Ribble Valley Borough Council
Council Offices
Church Walk,
Clitheroe
Lancashire
BB7 2RA

Phone: 0300 123 6780
Email: developeras@lancashire.gov.uk
Your ref: 3/2025/0891
Our ref: 3/2025/0891/HDC/KW
Date: 13 November 2025

Location: 18 Rogersfield Langho BB6 8HB
Proposal: Proposed first-floor rear and side extension and internal alterations.
Grid Ref: 370070 433833

Proposed Ground Floor Plan
Scale (1 : 50)

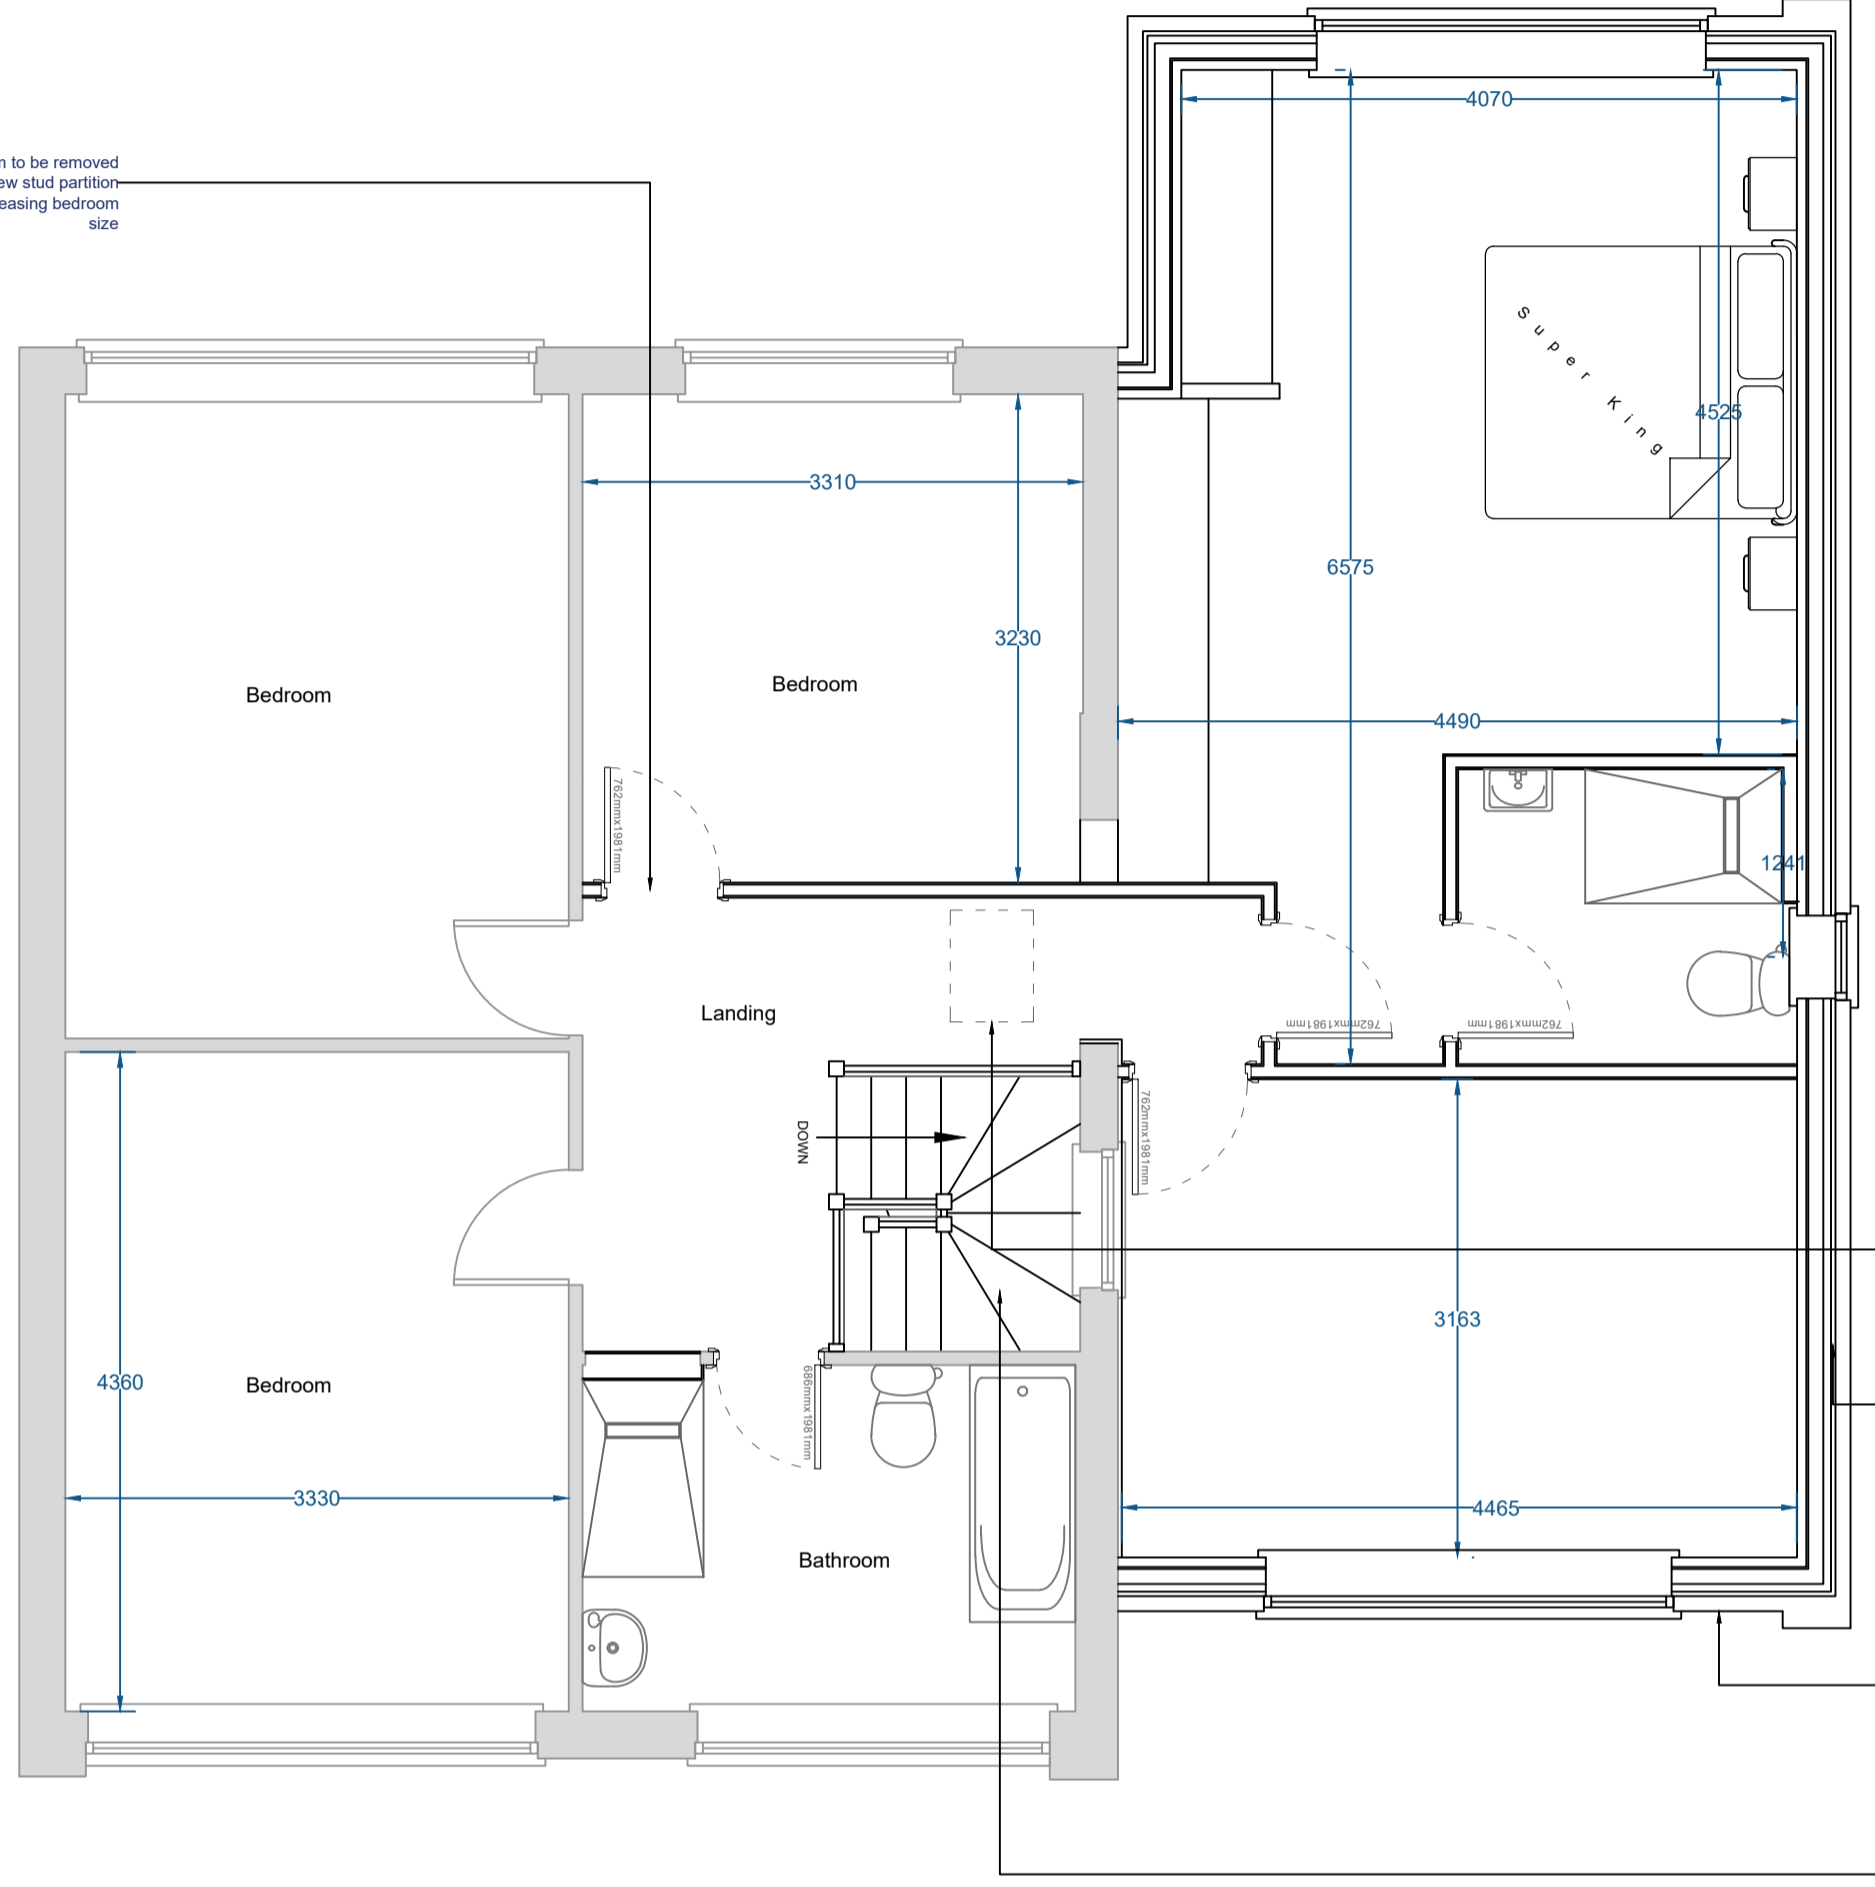
The proposal will increase the number of bedrooms within the dwelling from 4 to 5. The development will also amend the existing off-street parking provisions by reducing the existing garage. The recommended minimum internal dimensions for a single garage size is 6m in length and 3m wide. The recommended distance of 6m is based on the length of a large family car (Ford Mondeo Estate 4.58m long), clearance at the rear of the car (200mm), overhang of the garage door (600mm) and room to stand in front of the car and open/close the garage door (600mm). As the proposed garage will be smaller than the recommended internal dimensions, it cannot be considered to provide off street parking provisions.

However, the existing off-street parking provisions within the driveway will remain the same. Given the size of the existing driveway, it is likely to accommodate 3 off-street parking spaces, which meets the parking requirements for a 4+ bedroom dwelling as defined within the Joint Lancashire Structure Plan. As such, the effect of the development on the operation of the local highway network would be negligible.
